EL PASO COUNTY GRADING AND EROSION CONTROL PLAN CHECKLIST

EPC Project Number: CDR241

WELL NO. 22 TRANSMISSION LINE PLAN

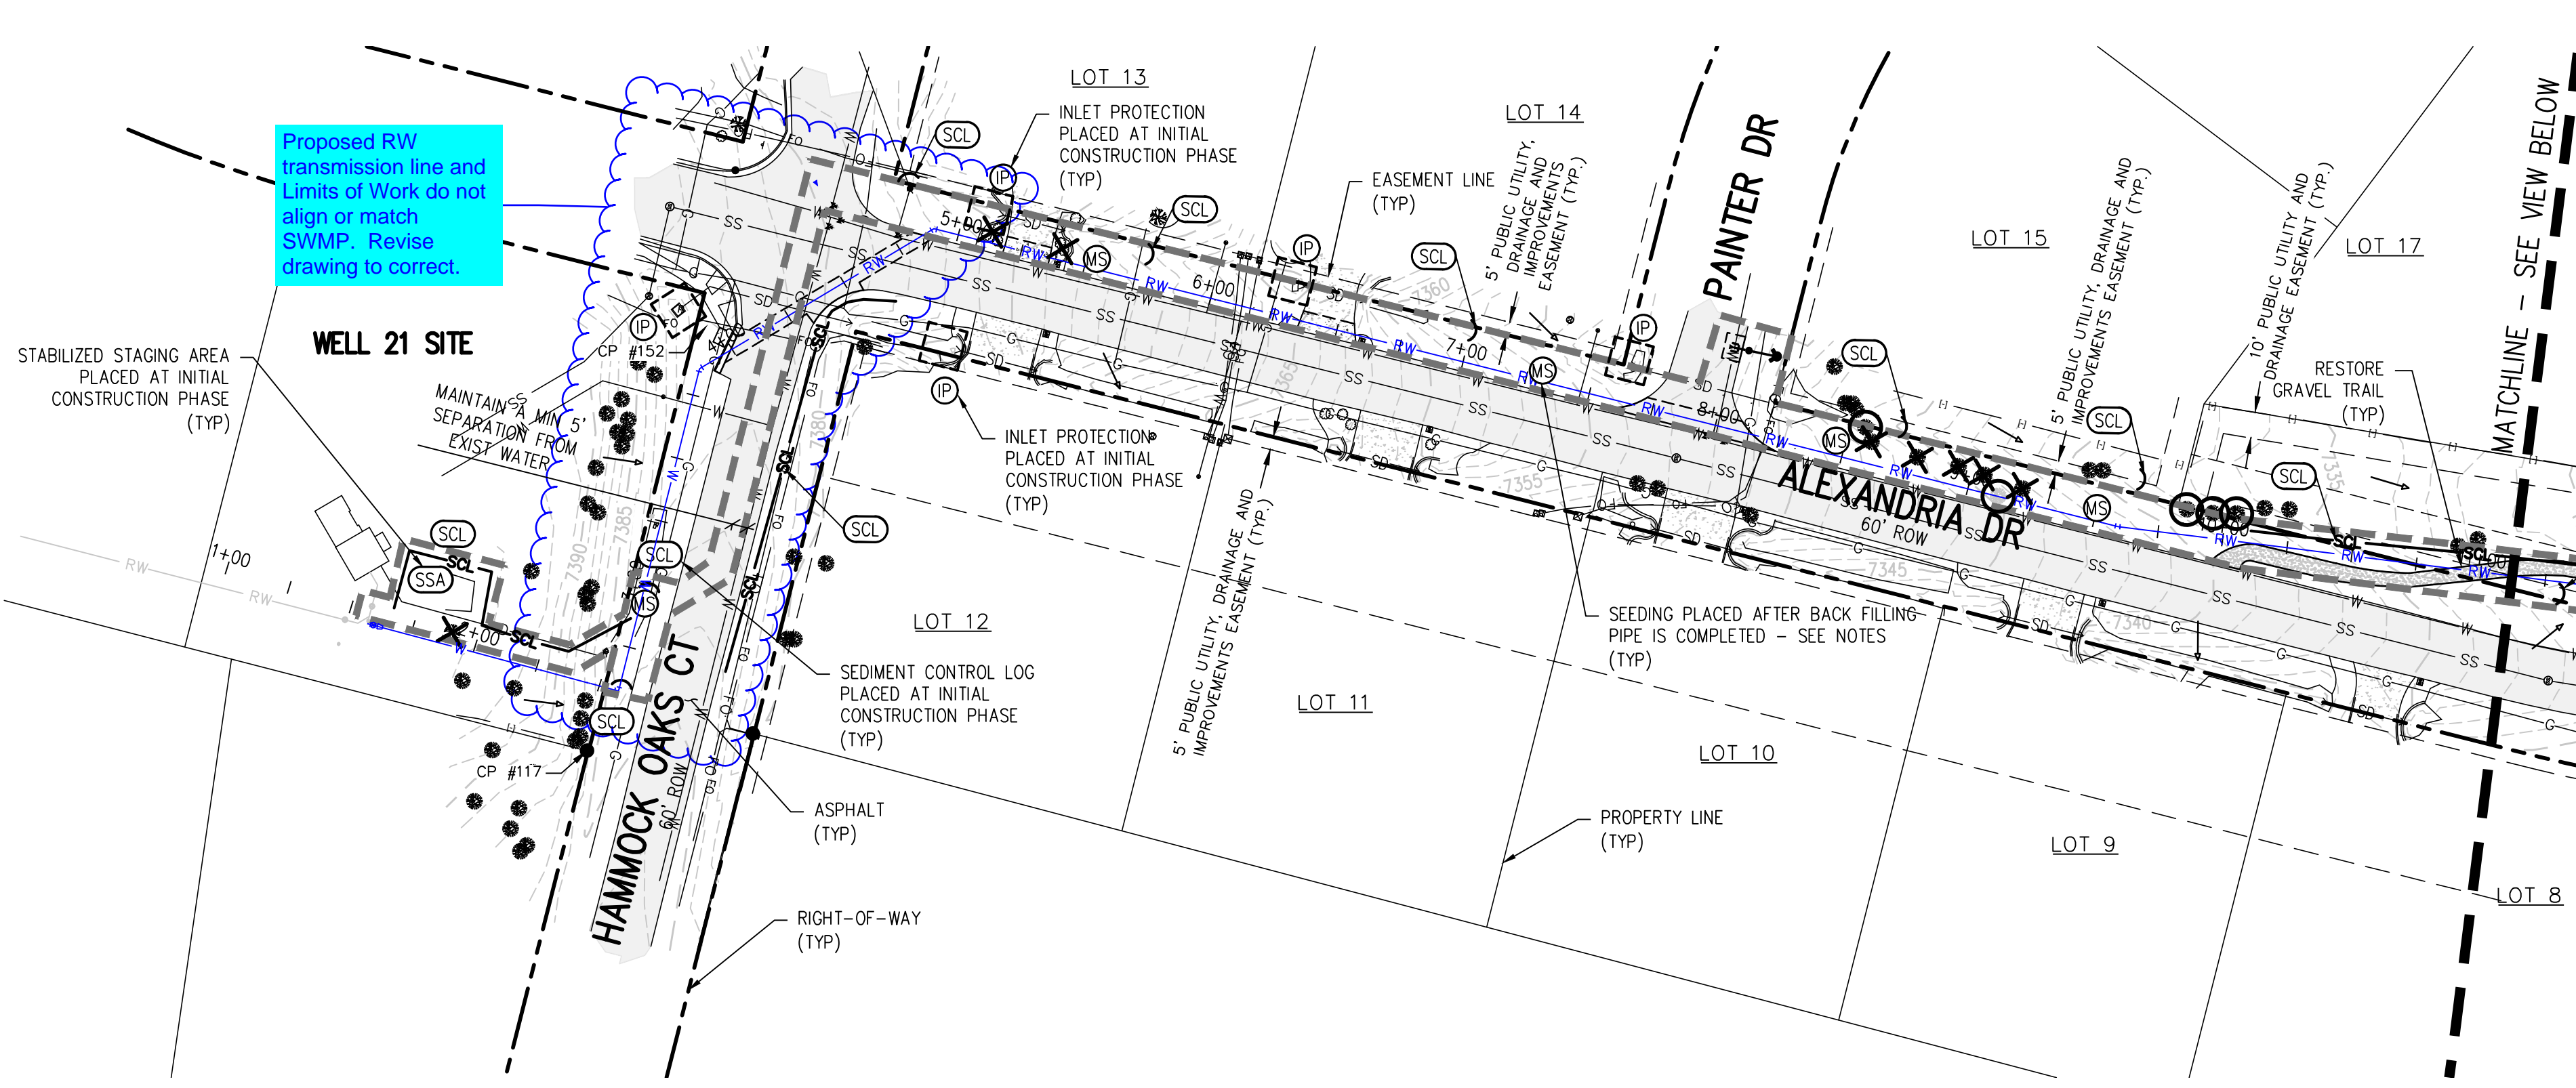
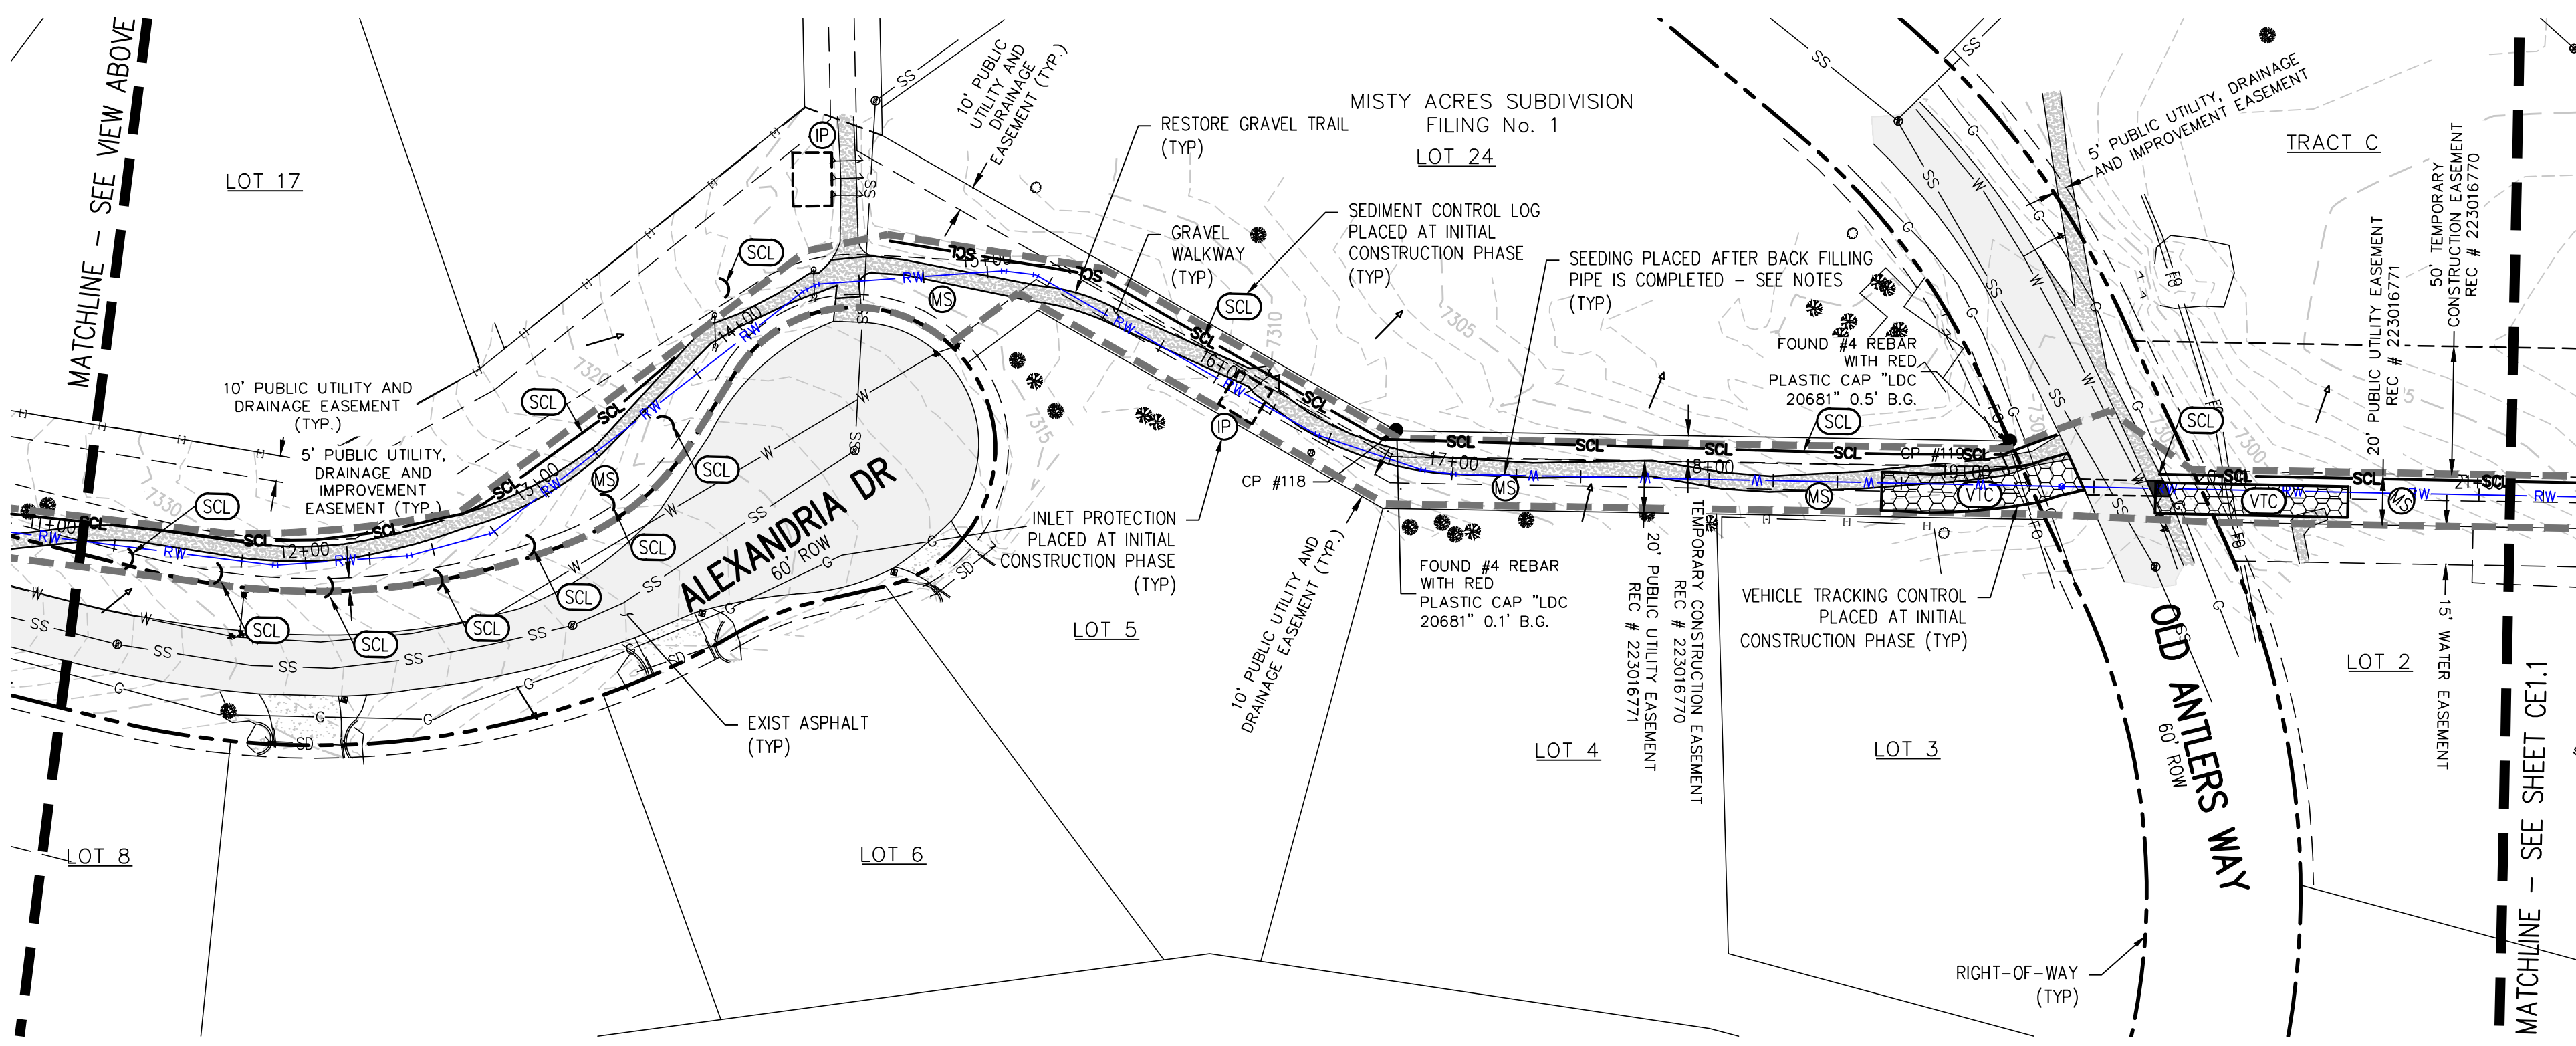
l	Existing and proposed contours 2 feet or less (except for hillside)		Y
m	Limits of disturbance delineating all anticipated areas of soil disturbance See comment on Sht CE1.0		
n	Identify and protect areas outside of the construction site boundary with existing fencing, construction fencing or other methods as appropriate		Y
o	Off-site grading clearly shown and called out		N/A
p	Areas of cut and fill identified		N/A
q	Conclusions from soils/geotechnical report and geologic hazards report incorporated in grading design (slopes, embankments, materials, mitigation, etc.)		Y
r	Proposed slopes steeper than 3:1 with top and toe of slope delineated. Erosion control blanketing or other protective covering required		N/A
s	Stormwater flow direction arrows		Y
t	Location of any dedicated asphalt / concrete batch plants		N/A
u	Areas used for staging, storage of building materials, soils (stockpiles) or wastes. The use of construction office trailers requires PCD permitting		Y
